**Comments on the air quality aspects of the EIS of the
WestConnex M4 East proposal (SSI 6307)**

Review of the West Connex EIS

Written by Ian Longley and Åke Sjödin on behalf of the Advisory Committee on Tunnel Air Quality

Figure J-6 Comparison between measured and predicted total NO_x concentrations at OEH and RMS air quality monitoring sites

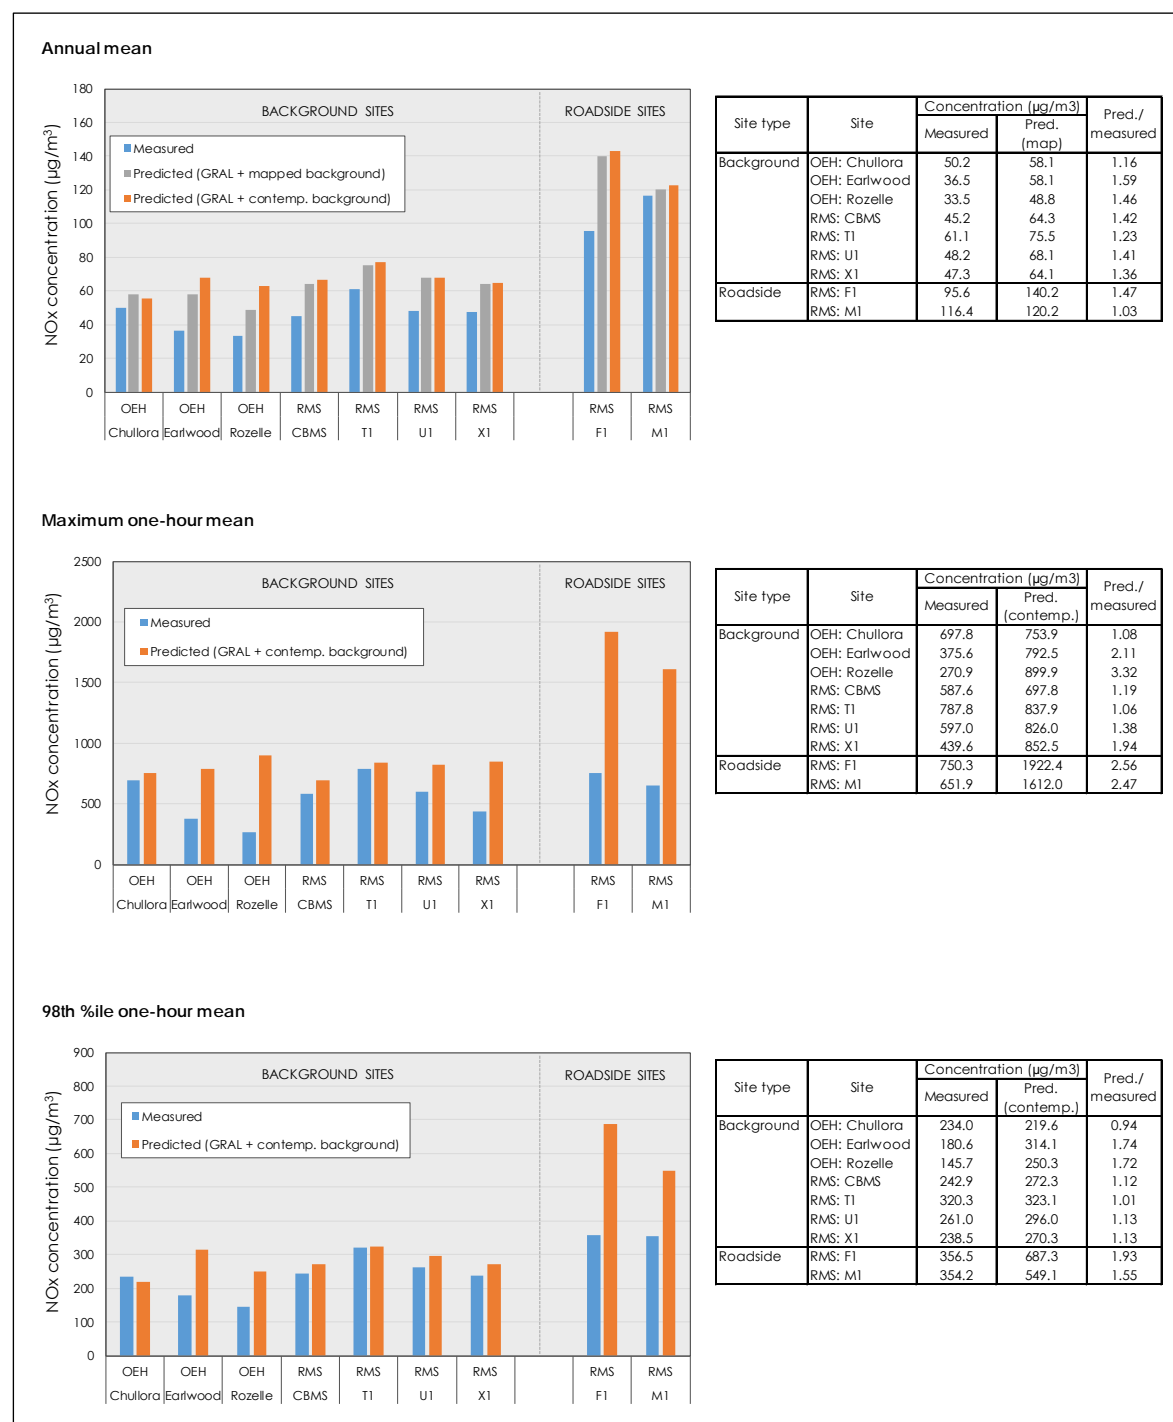
Monitoring data indicates a large divergence in concentrations between site M4E:04 (Concord Oval) and the other three roadside sites: 01, 02 and 03 (Table J-2). This is not reproduced by GRAL. Overall GRAL appears to predict a smaller range of concentrations between the five monitoring sites than is actually observed. This may indicate that GRAL under-predicts at higher total concentrations (i.e. very close to major roads) and possibly over-predicts at urban background locations. The Concord Oval site differs from the other roadside sites in being closer to the road and potentially, to a major intersection. This phenomenon may also be responsible for the differential performance in GRAL predicting the two M5 East portal sites F1 and M1 (figure J-6).
